City of Portland, Maine - Building or Use Permit Application

Permit No: 02-1252	Issue Date: NOV 20	CBL: 176 G018001
-----------------------	------------------------------	---------------------

Proposed Project Description:
Construct 10 x 18' Addition/Expand Kitchen: Create Entry: Expand Bedroom and Bath

Comments: 11/14/02 spoke to contractor about concerns and he will submit necessary info

REVISIONS TO DRAWINGS 1 THRU 9

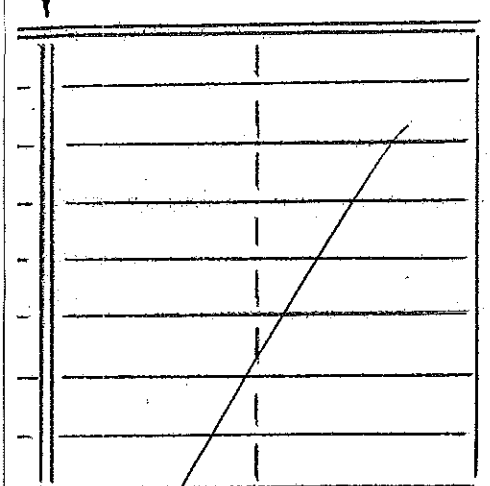
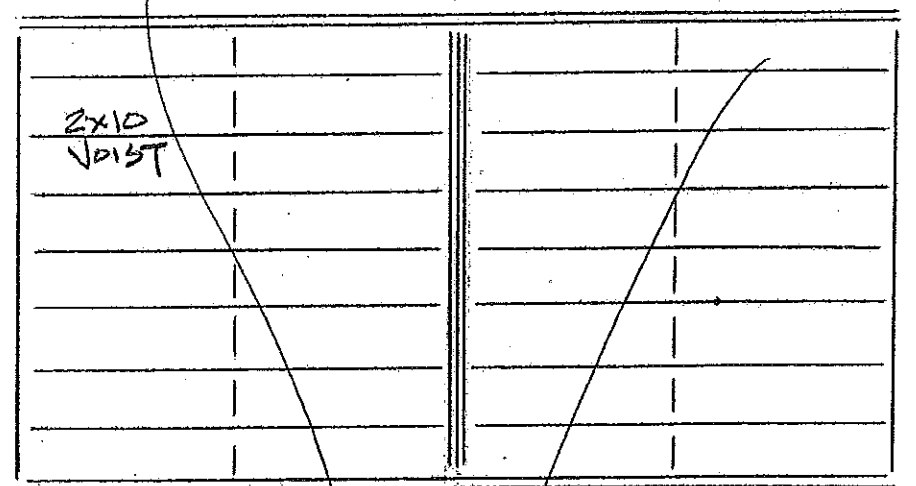
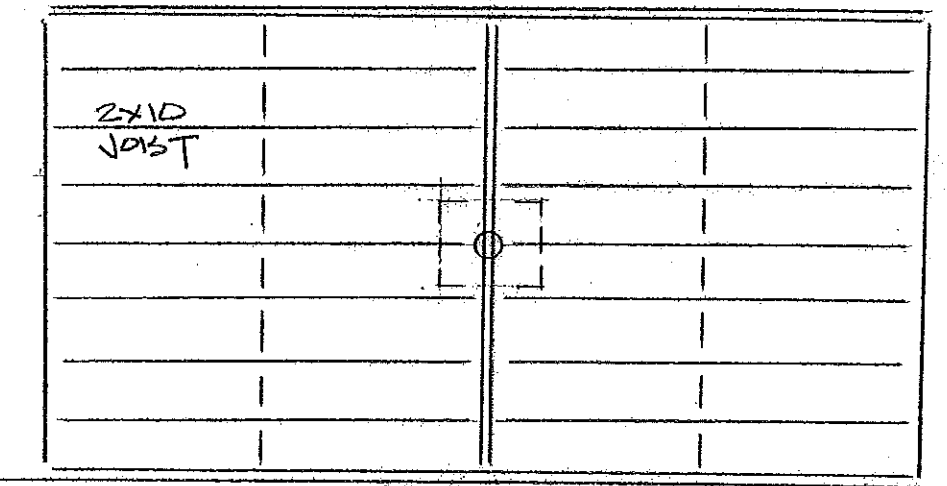
The contractor understands that if the existing bearing wall is relocated 18" over, a stamped plan must be submitted prior to this work showing the joist tie in and continual bearing.
